RE: **7212 Menaul NE**
Grading Plan Stamp Date: 6/19/19
Drainage File: H19D040

Based on the submittal received on 6/20/19, the grading plan cannot be approved until the following corrections are made:

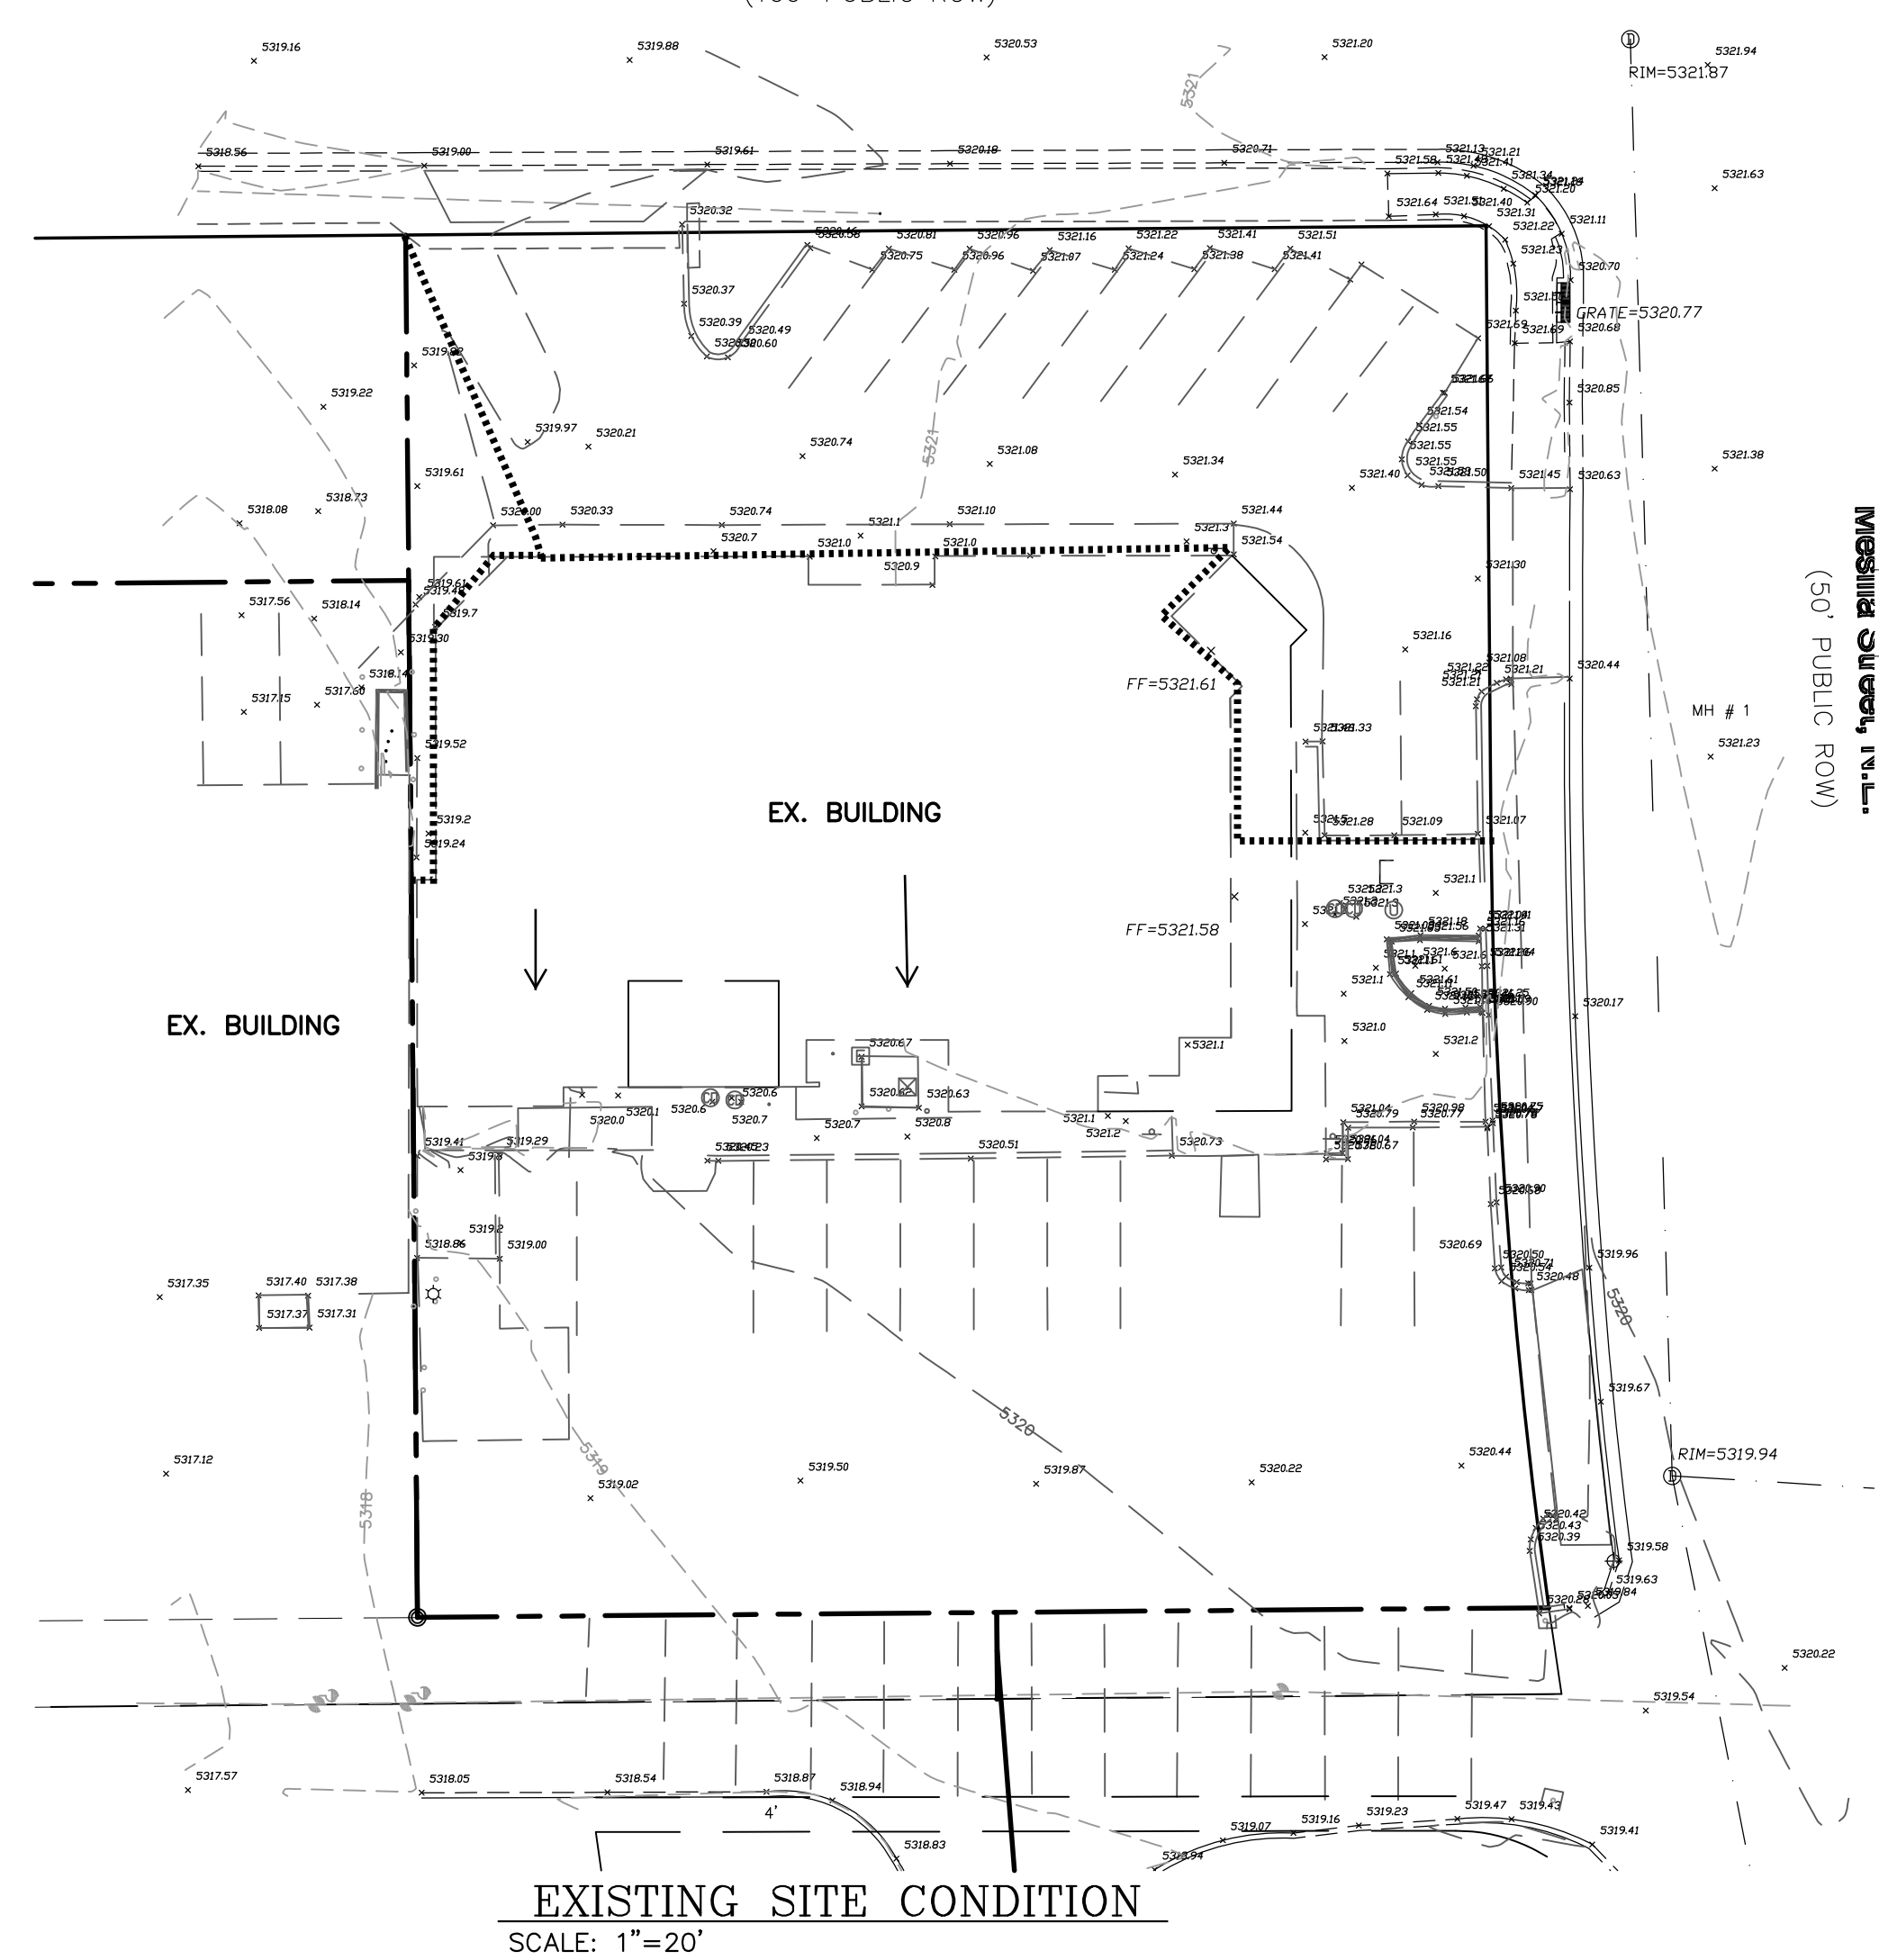
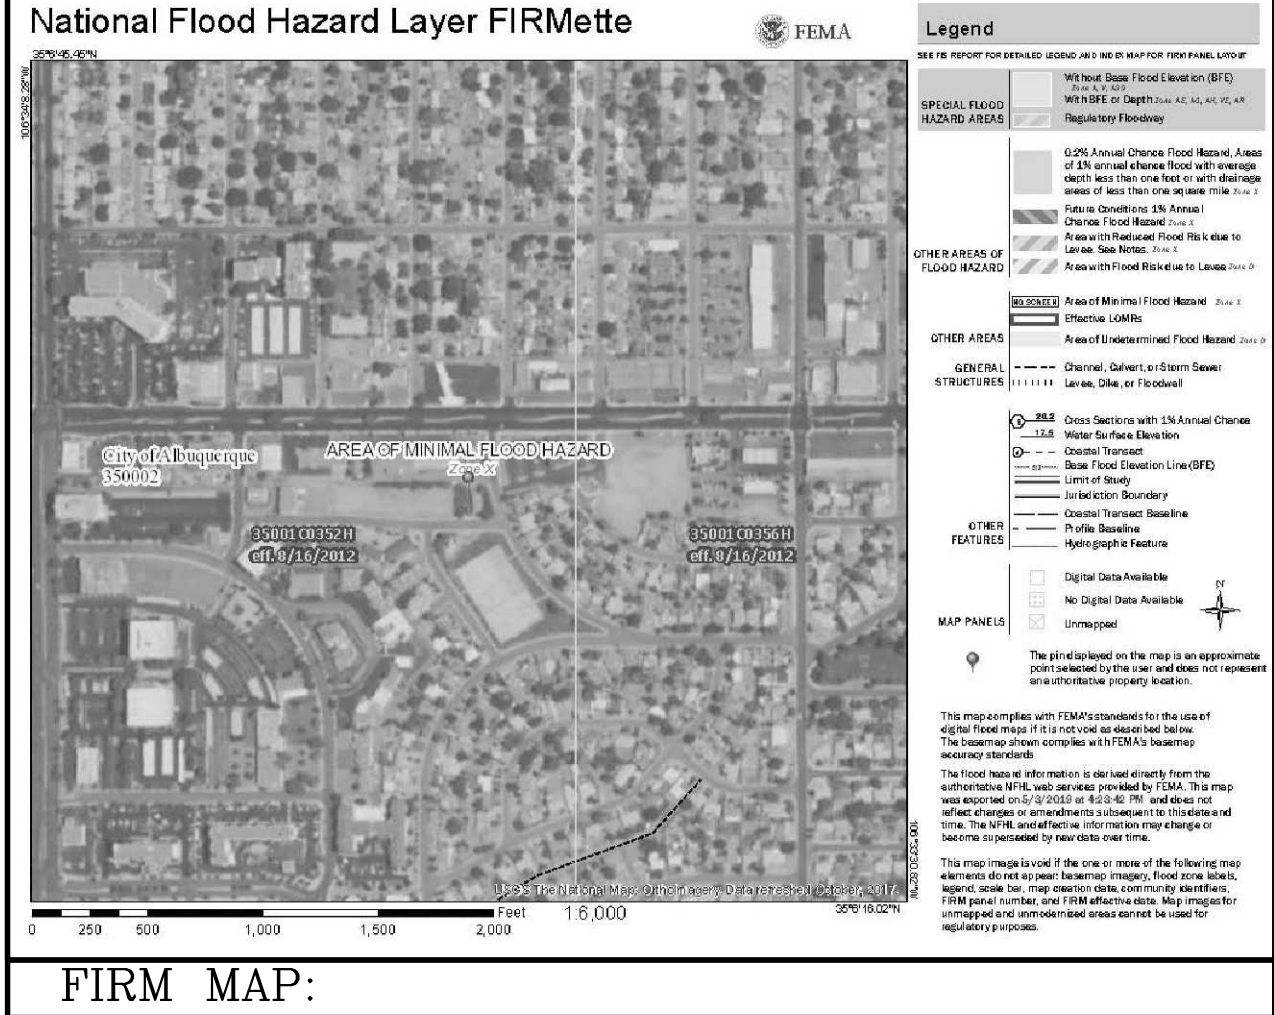
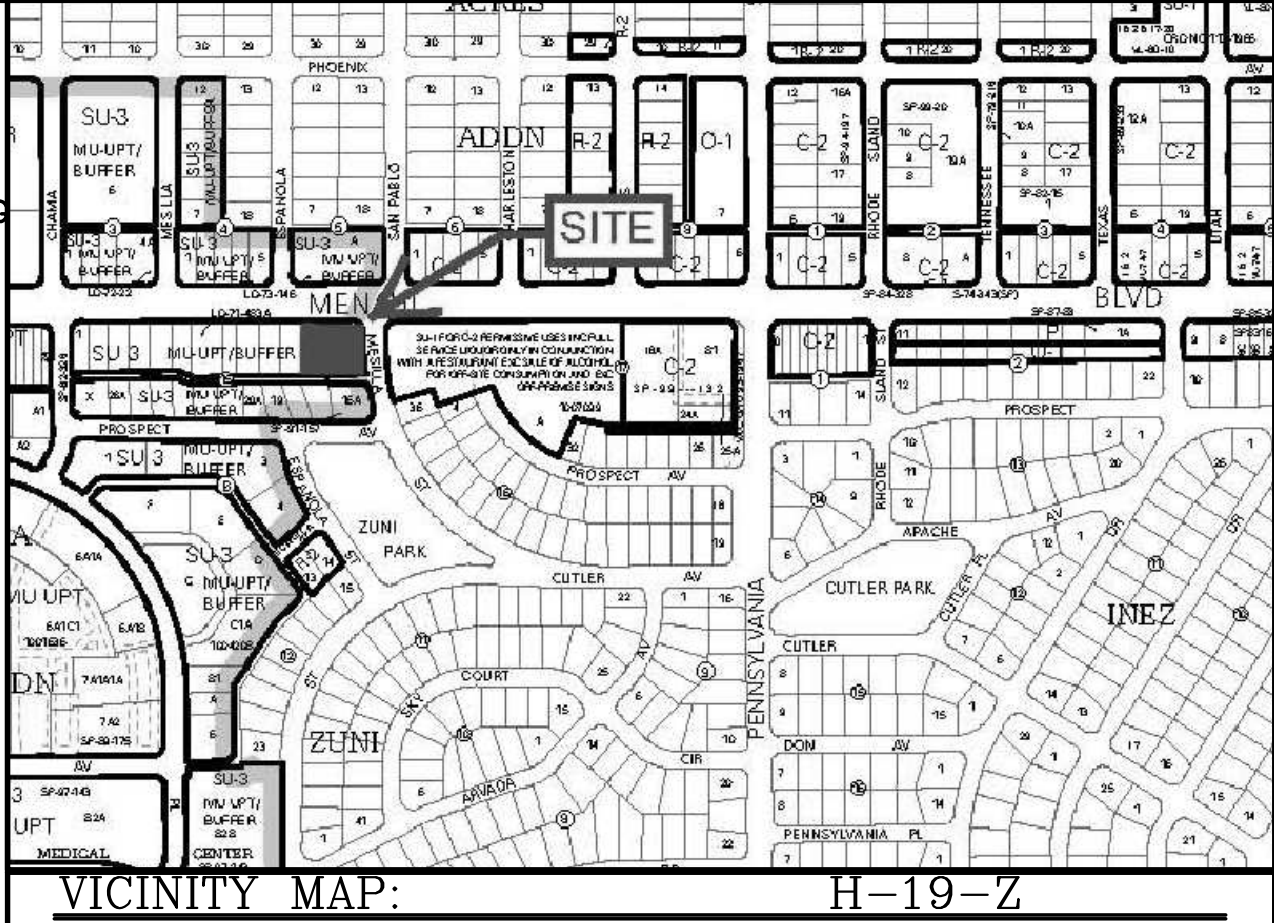
1. Show the grading and site work for repaving the alley; this work is required per the approved TCL. Modify the note to state "No work shall be performed in the Alley ROW without an approved work order or excavation/barricading permit." A modified alley section may need to be approved by Transpiration (and Hydrology) to keep public water from entering private property.

2. The drainage calculations and narrative are missing from the plan now.
3. Including the inlet pump and force main seems unnecessary. A valley gutter or trench drain w/ drain line through the curb, along the property line, seems more economical.

4. If the force mains stays, include a detail for the pond, curb-cut outfall, and force main outfall, including elevations. Right now it appears the force main outfalls at 20.0', but the pond outfalls at 20.27', meaning the pond will back up into the force main and the pump will run until it evaporates.
